Our Ref: J4155230721

23rd July 2021

Re: Application 3/2020/0009 Response to LCC Letter

J4155 DR07 -

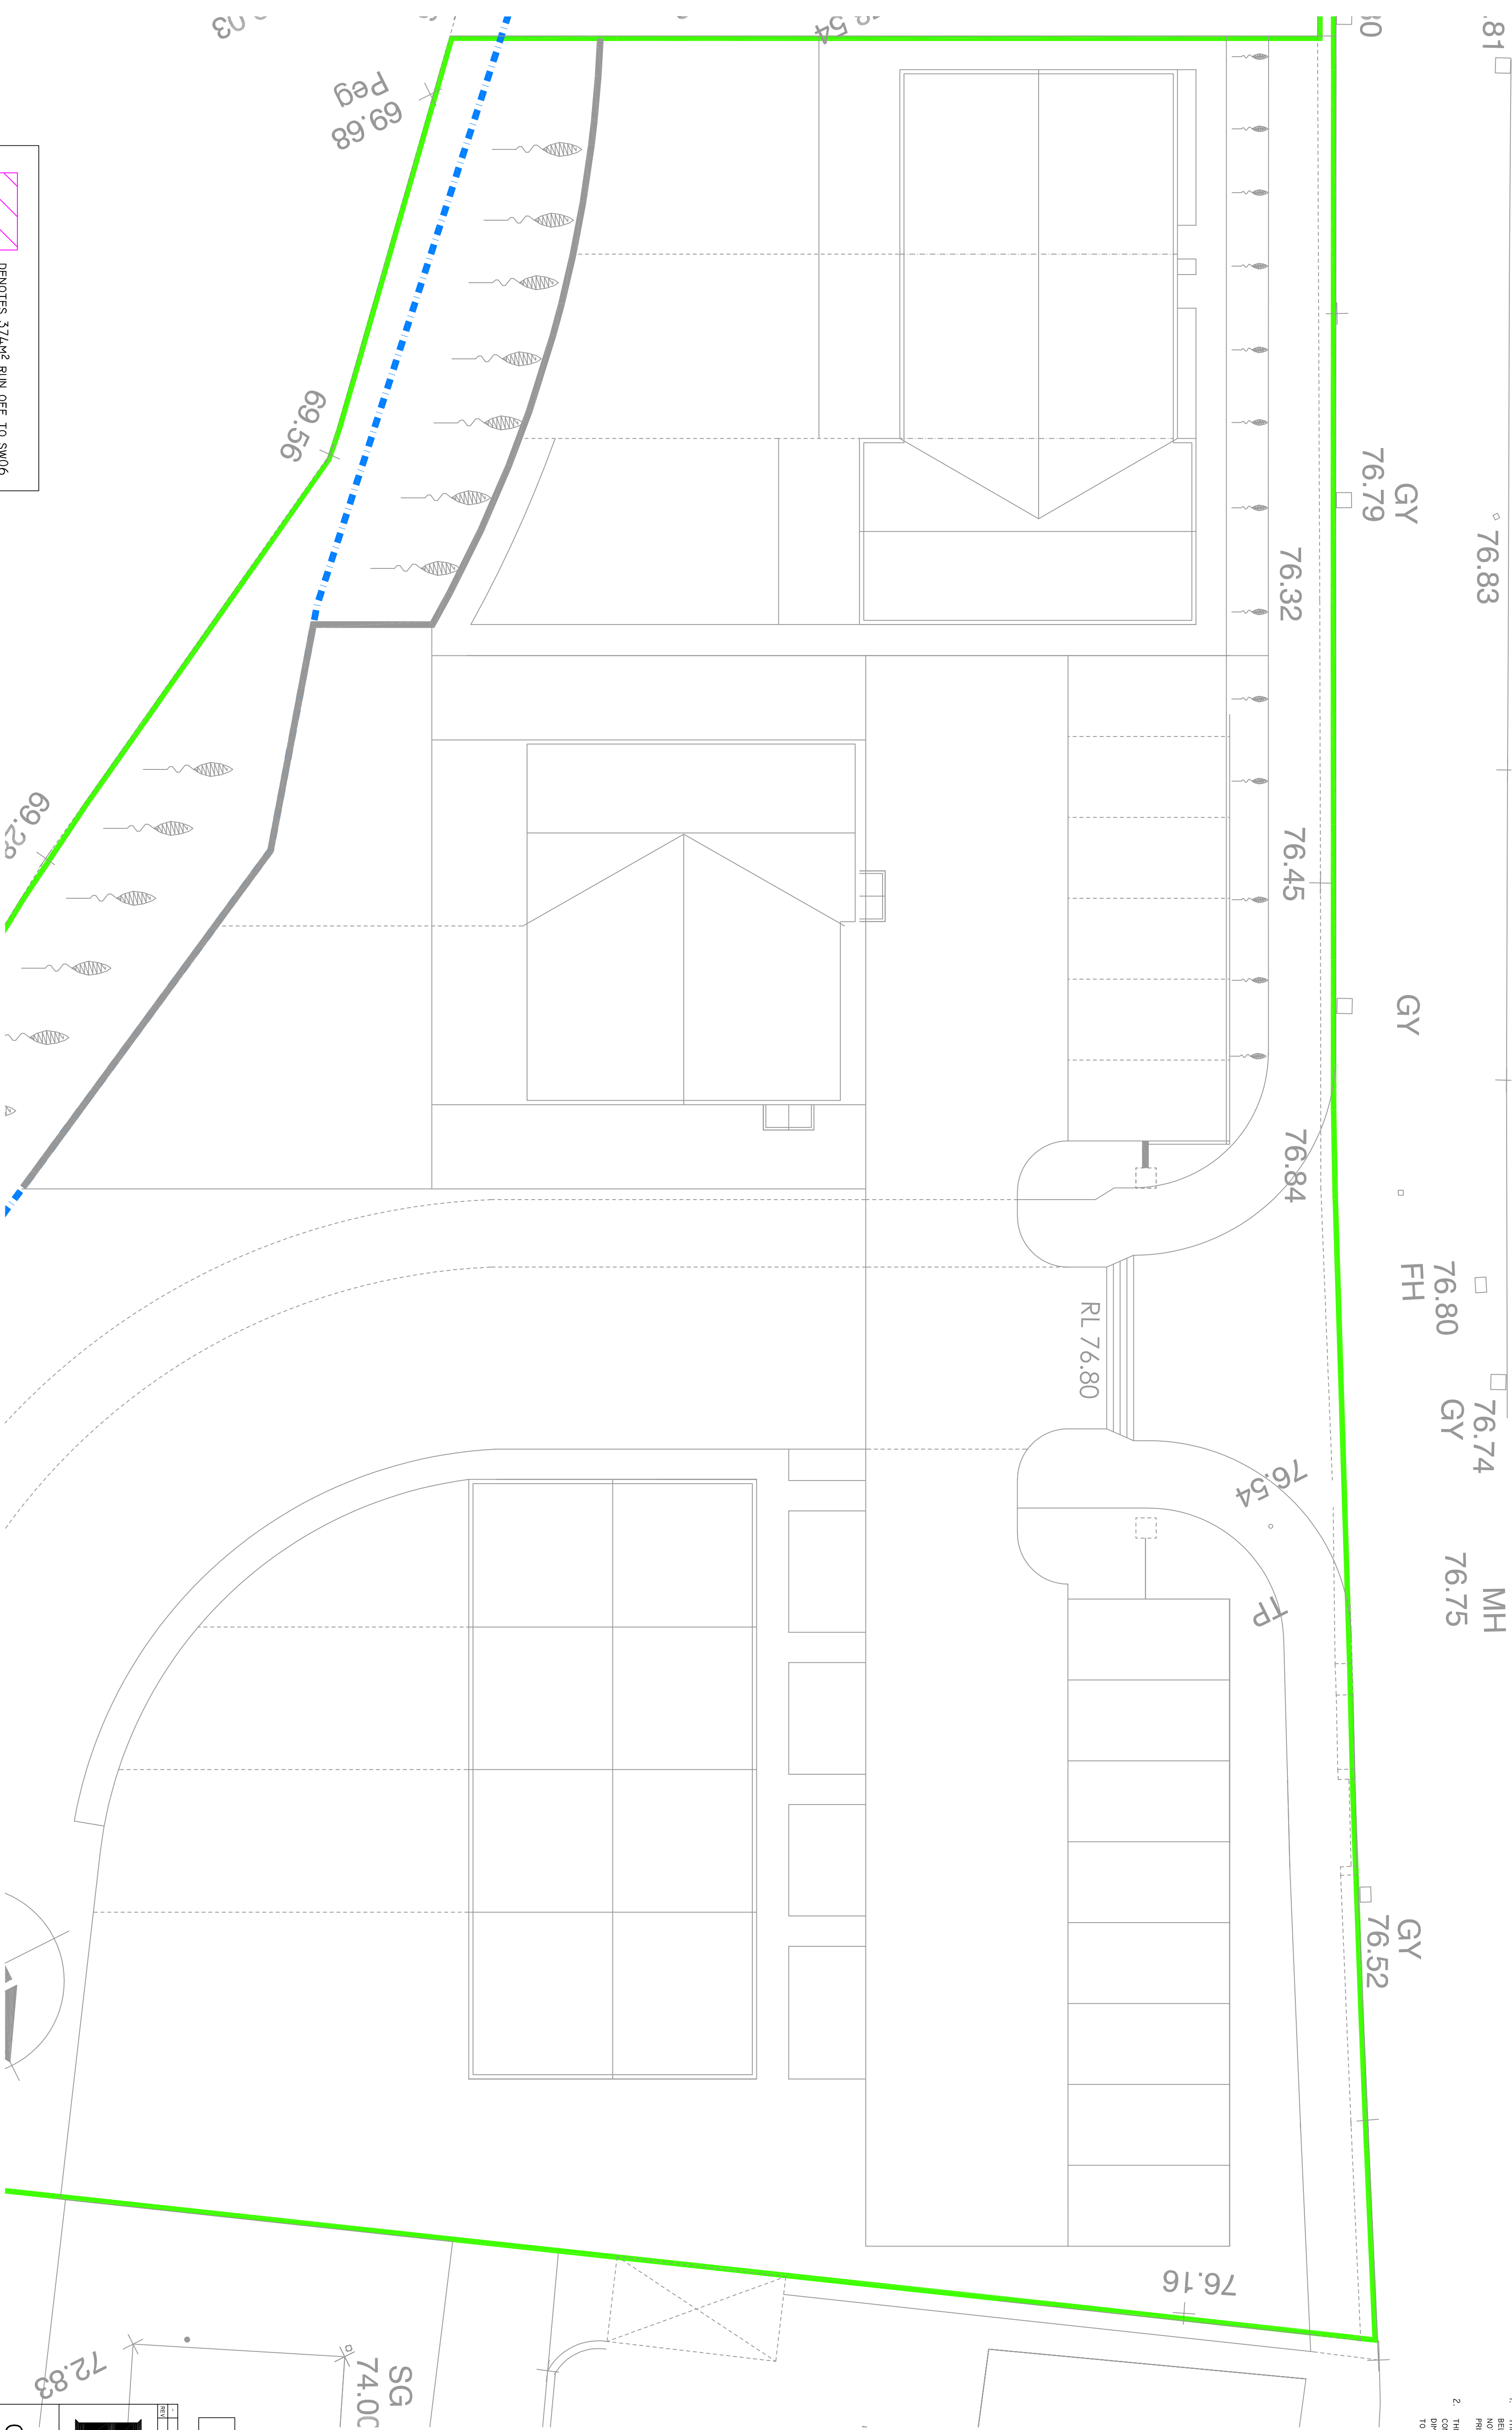
1. Please see revised drawing J4155 DR05 for scheme layout
2. Please see MicroDrainage calculations document J4155 Hydraulic Calculations Rev A
3. Please see new drawing J4155 DR07 for contributing area plan
